Date 28 November 2017

**RE: 6/2017/2385/COND - Queenswood School, Shepherds Way, Brookmans Park, Hatfield, AL9 6NS**

Thank you for your re-consultation in relation to the above planning application for the Submission of details pursuant to conditions 1 (Material samples), 2 (tree protection plan), 3 (soft landscape plan) and 5 (surface water drainage scheme) on planning permission 6/2016/2675/MAJ dated 20/07/2017, at Queenswood School, Shepherds Way, Brookmans Park, Hatfield, AL9 6NS.

Title
SURFACE WATER DRAINAGE STRATEGY

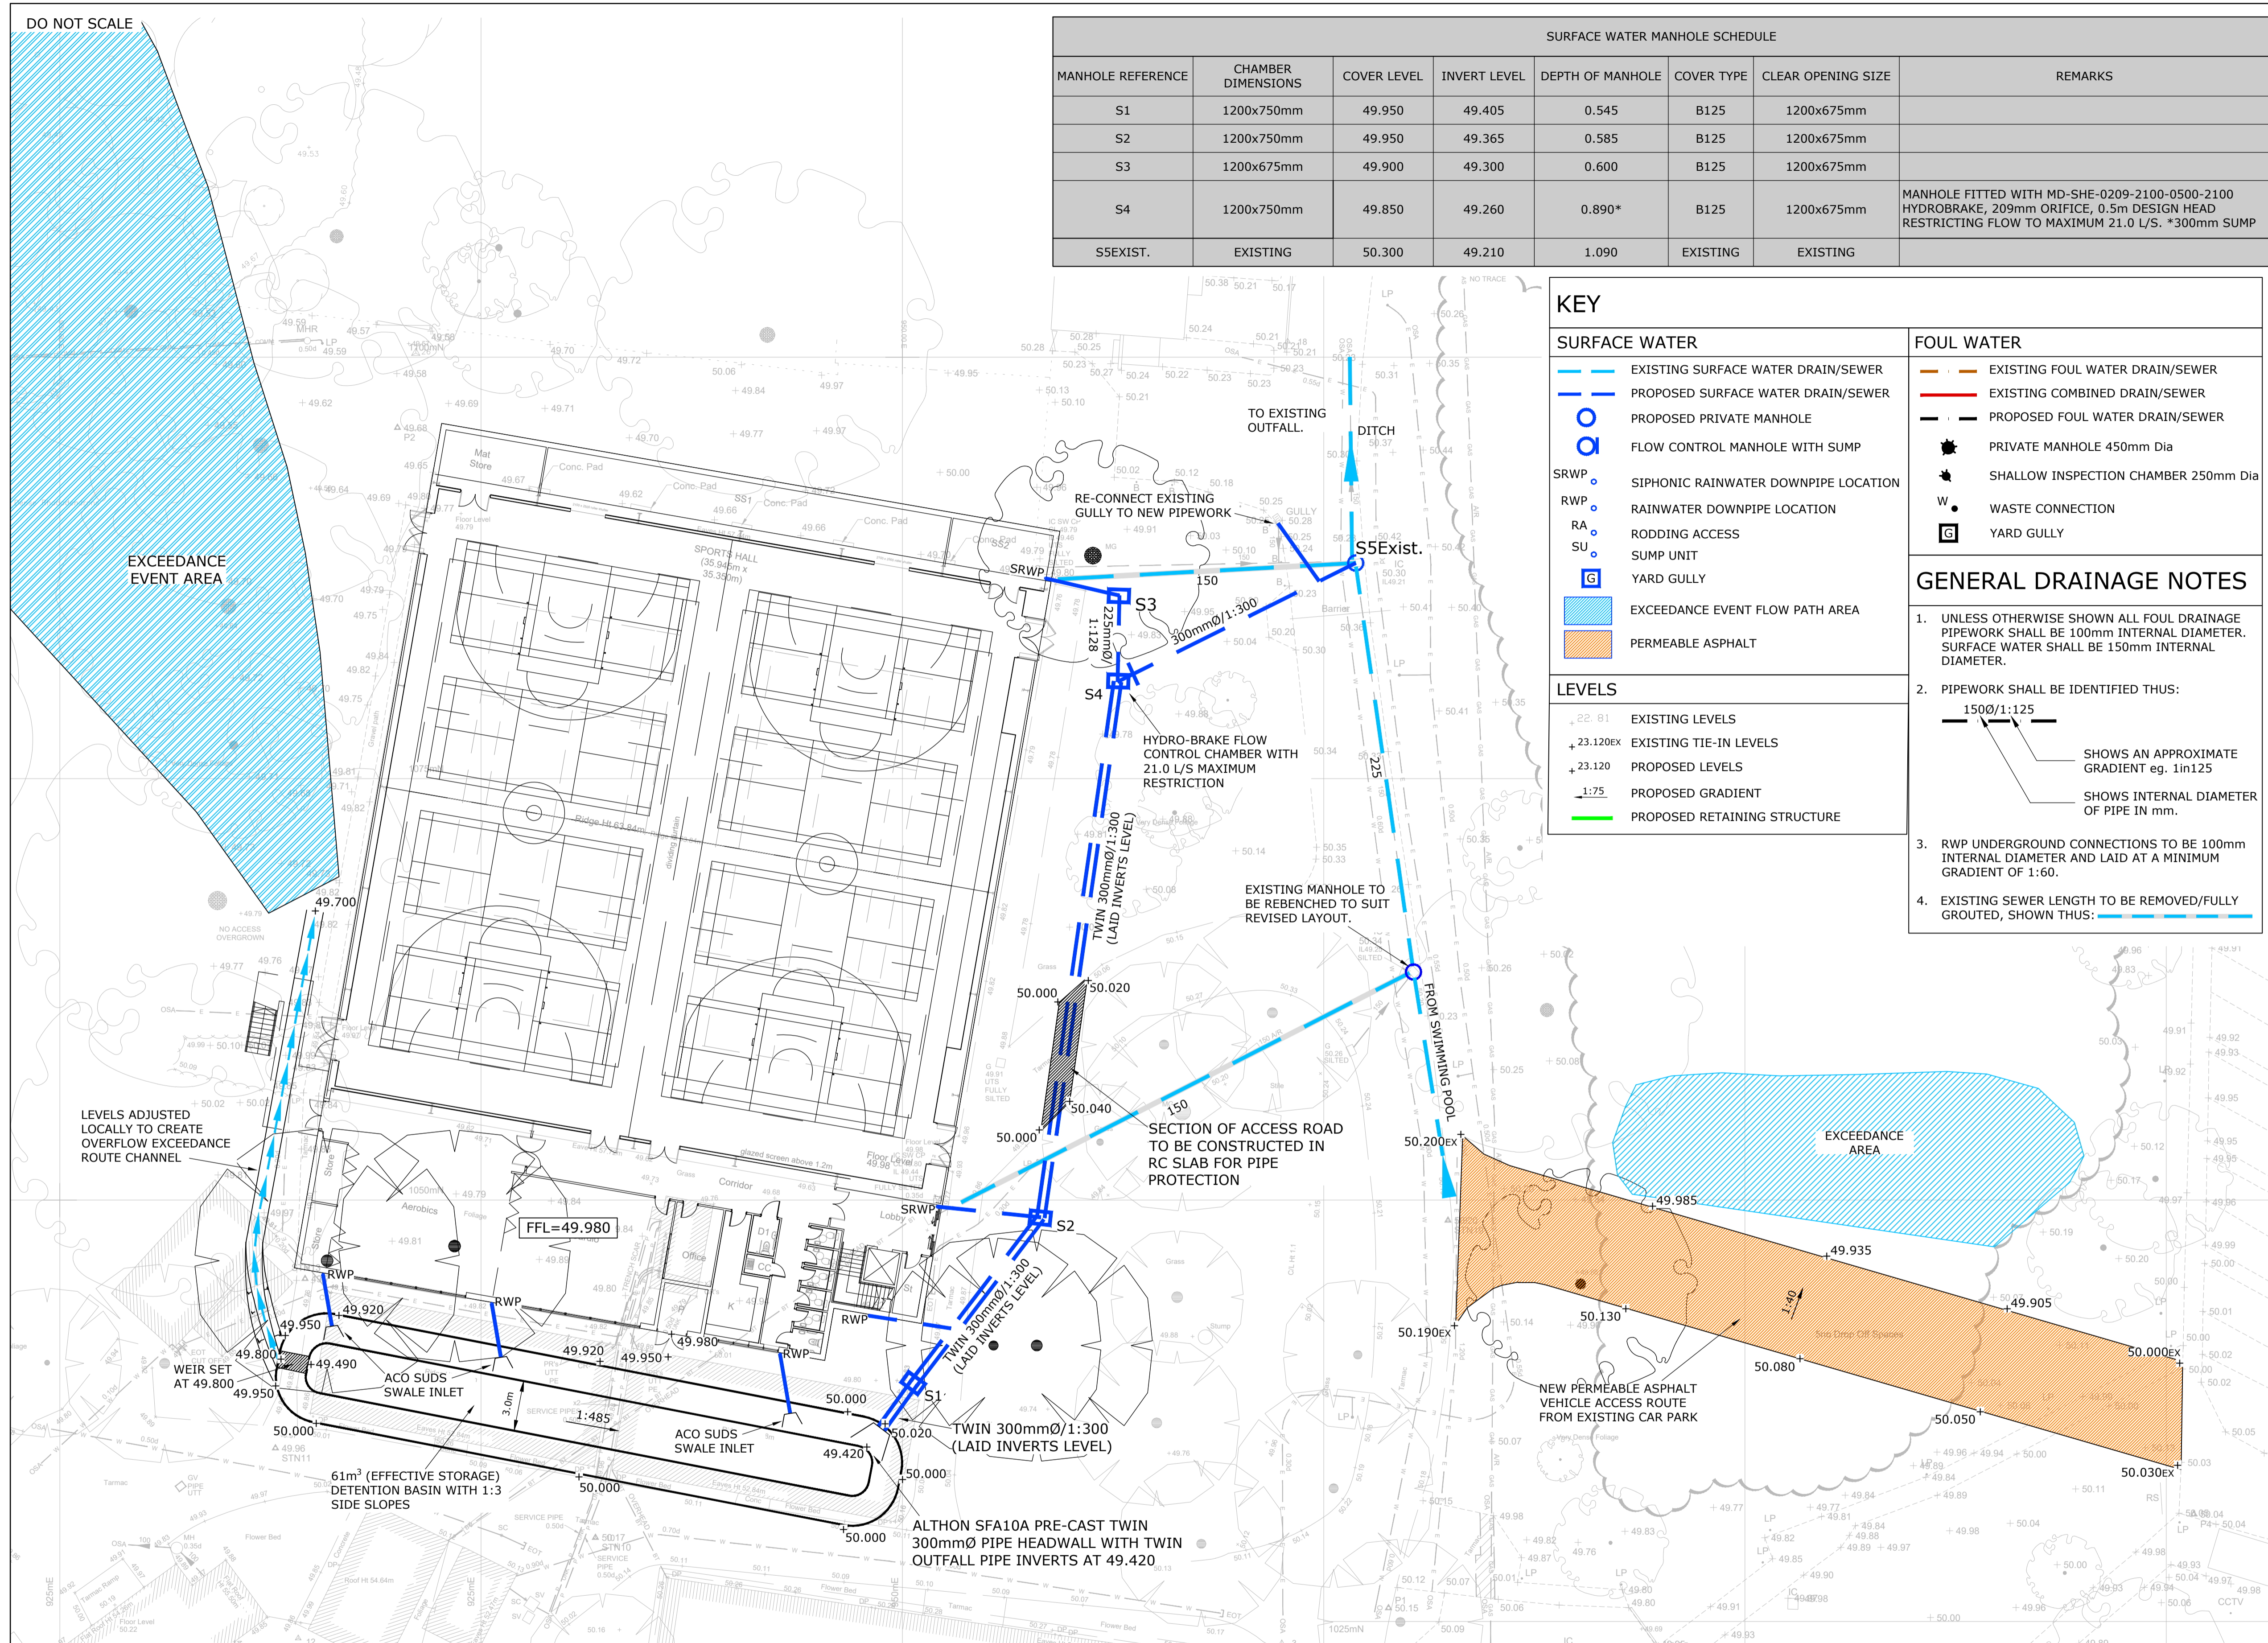
The applicant has proposed to store surface water in the detention pond, providing 61 m<sup>3</sup> of effective storage and discharge into the existing surface water sewer on the site at the rate of 21 l/s. The final discharge point of surface water is an ordinary watercourse.

Therefore, we advise the LPA that the proposed surface water drainage scheme is feasible and we would advise to discharge the Condition 5.

Title
**DETENTION BASIN
SECTIONS**

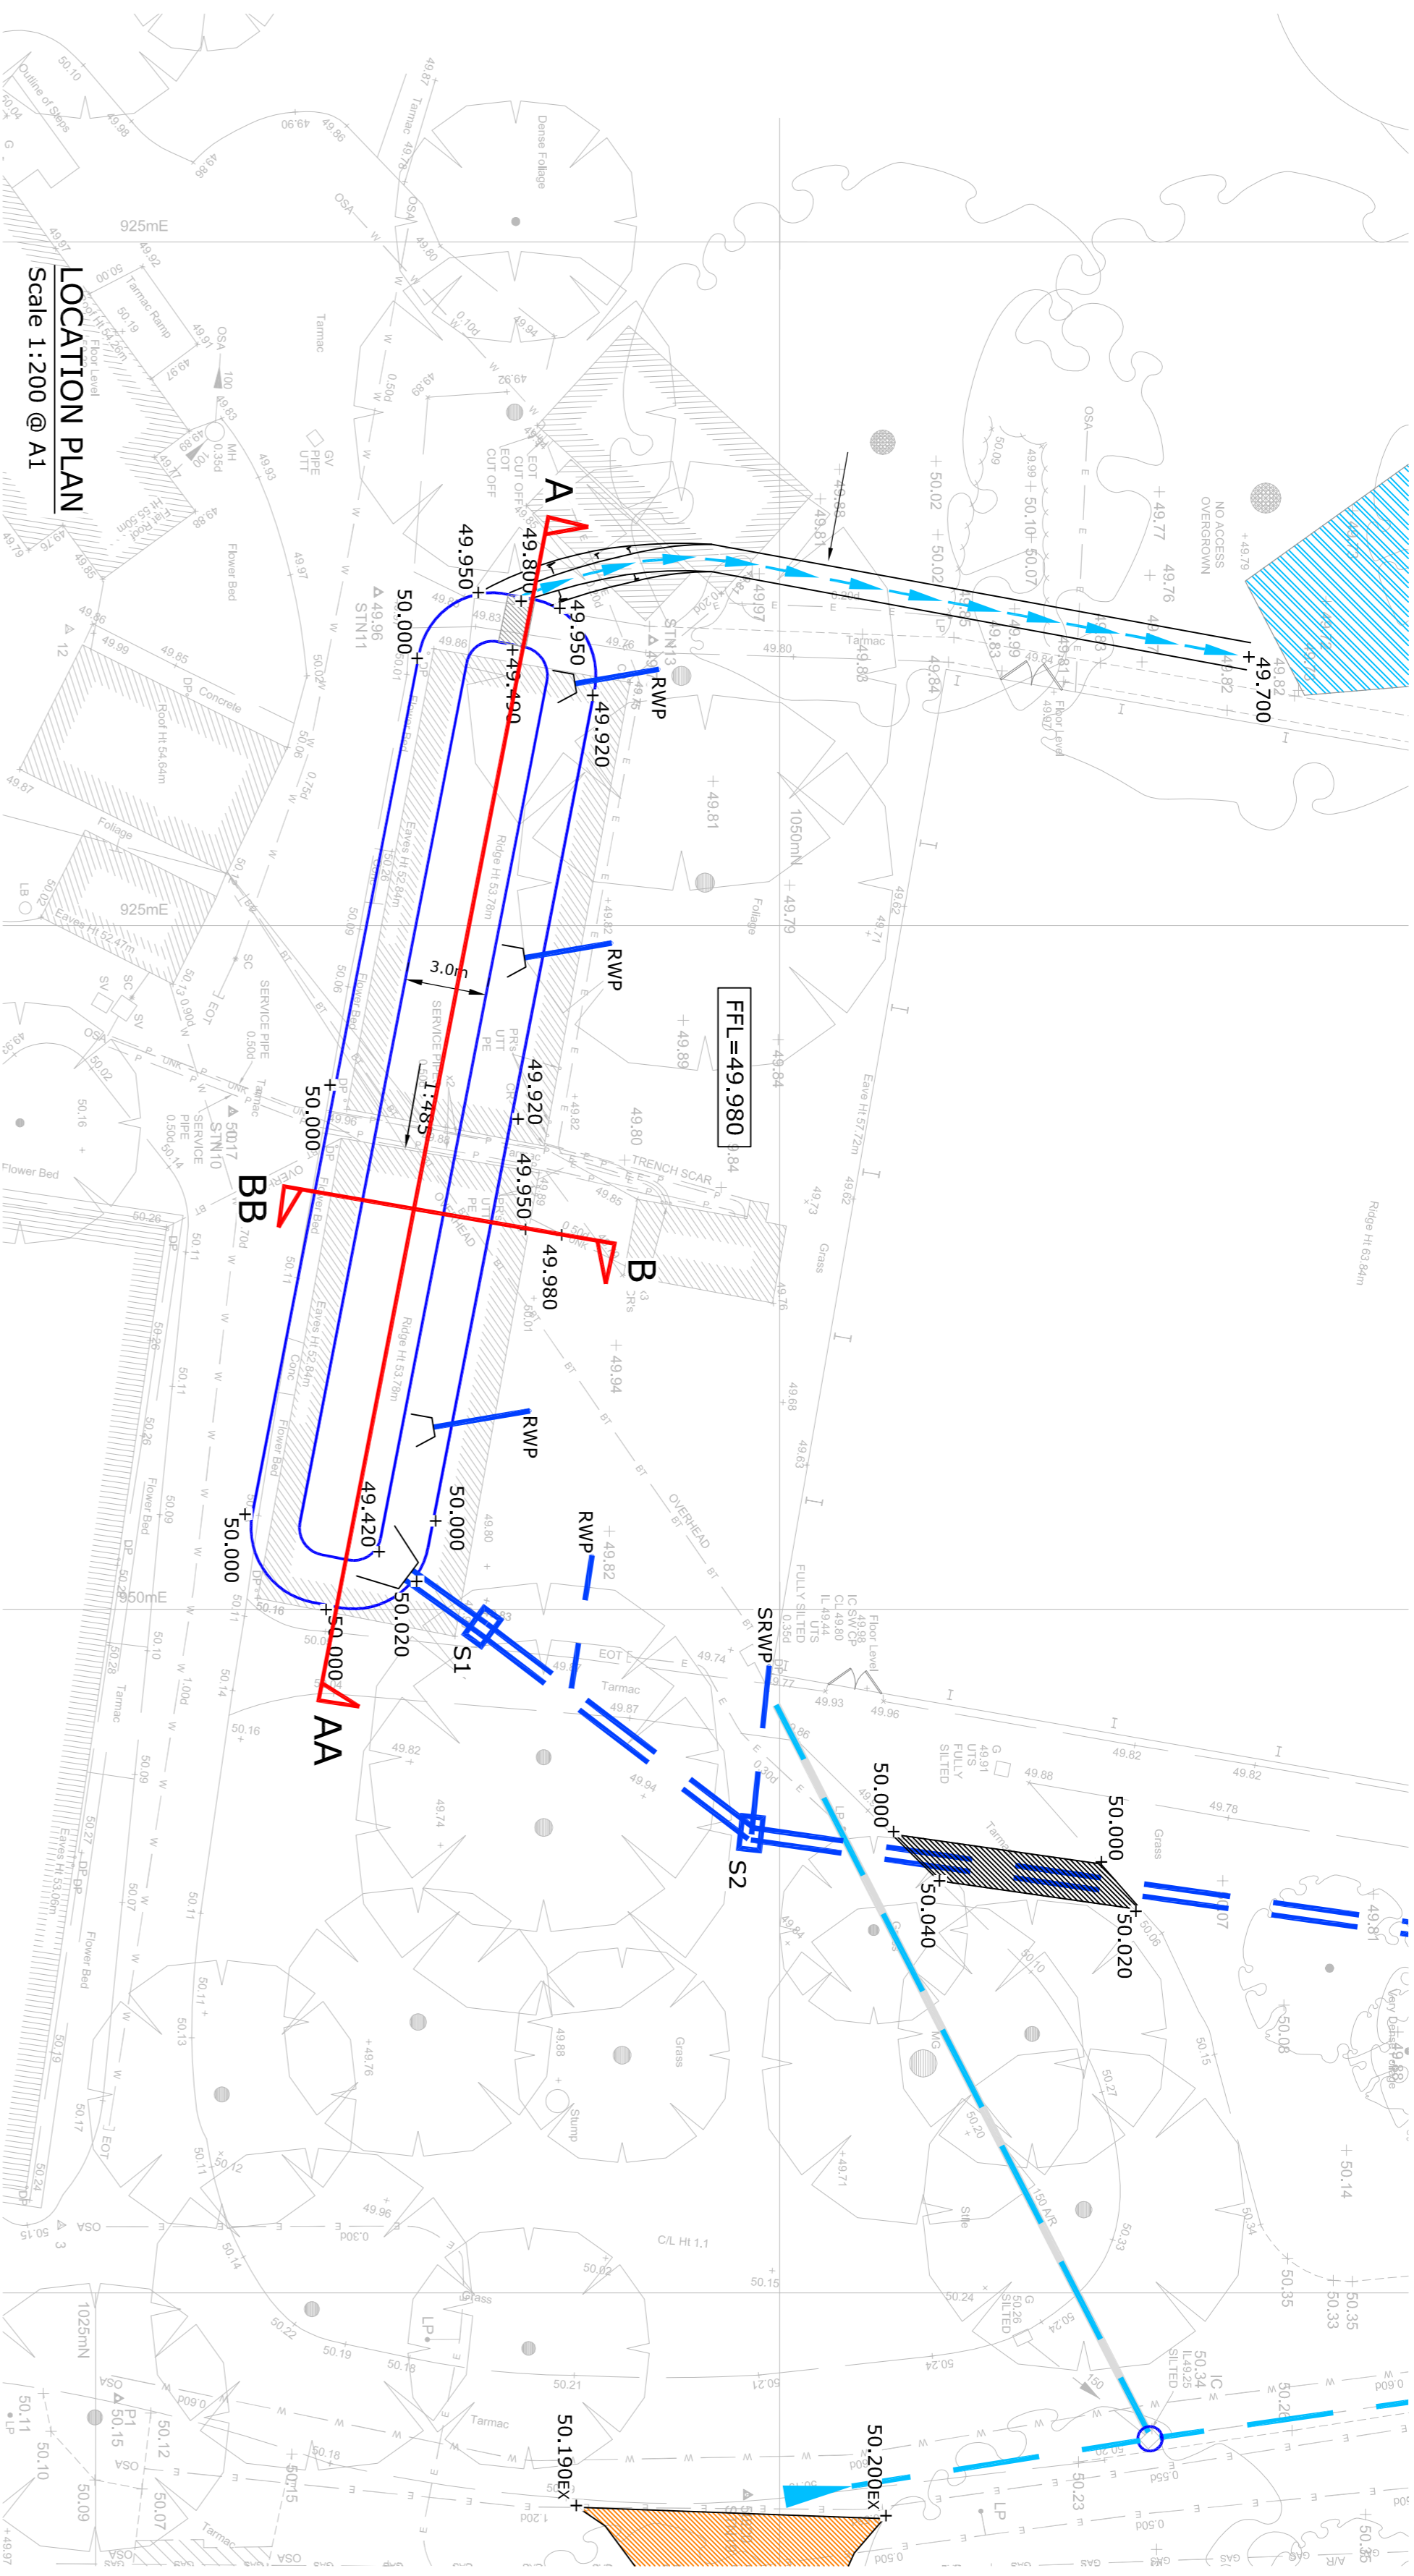
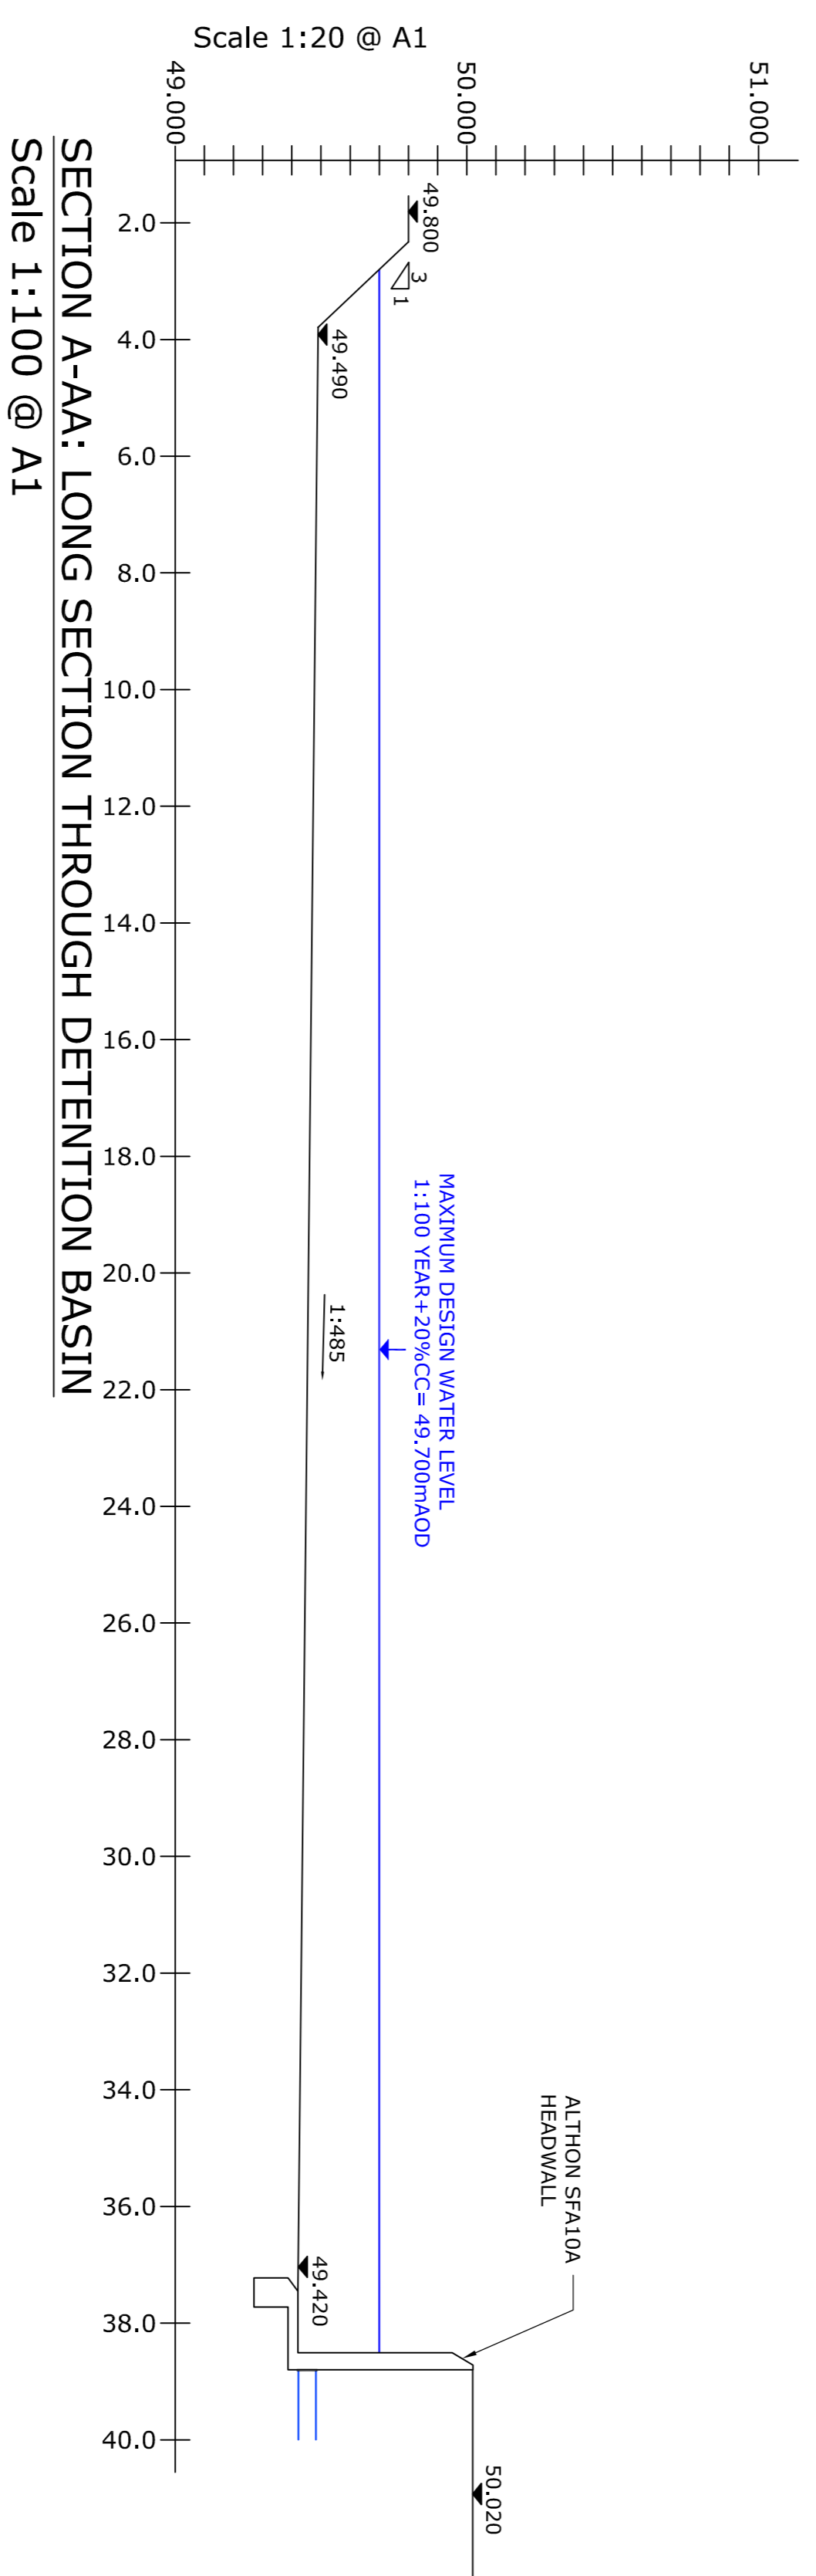
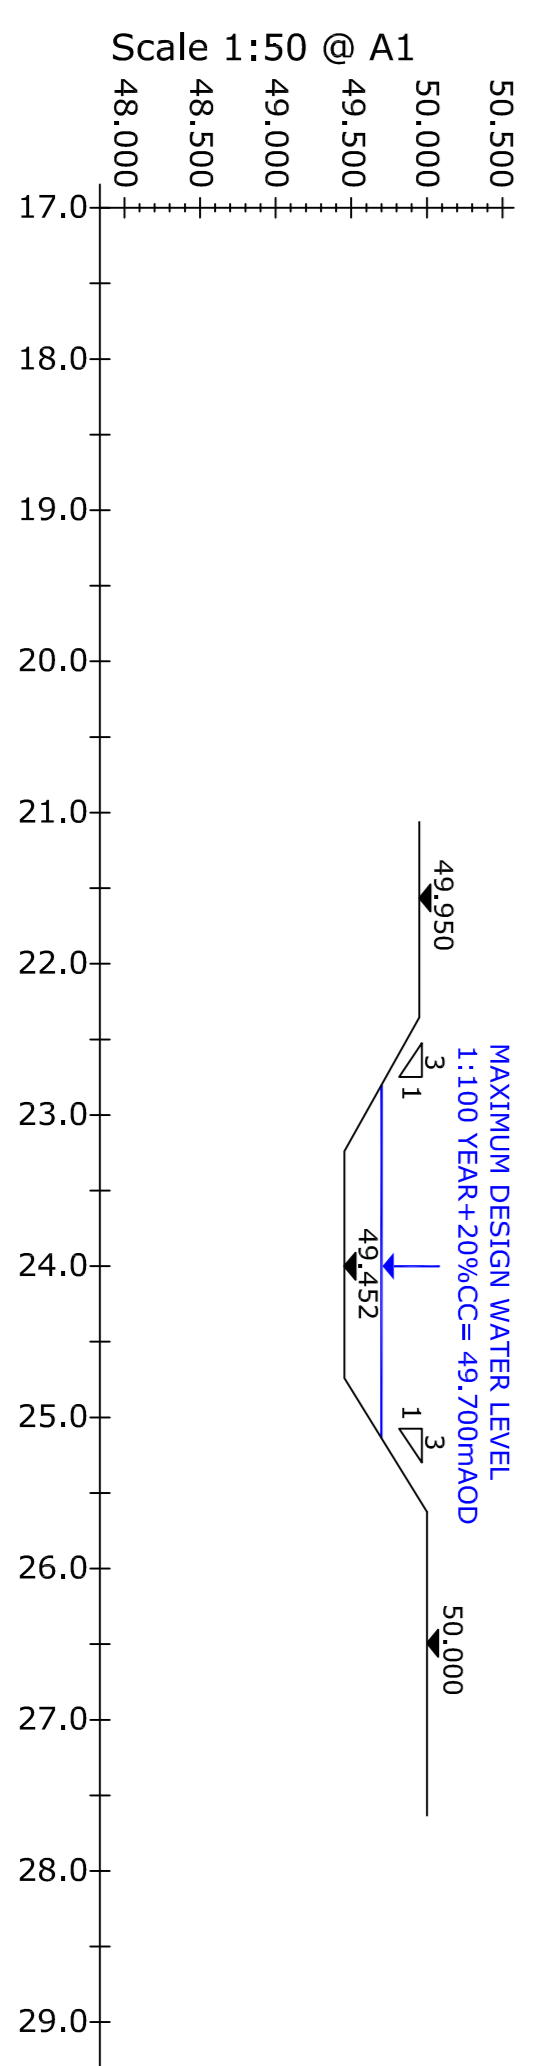
The applicant has provided detailed drawings of the proposed SuDS features including their size, volume, depth and any inlet and outlet features.
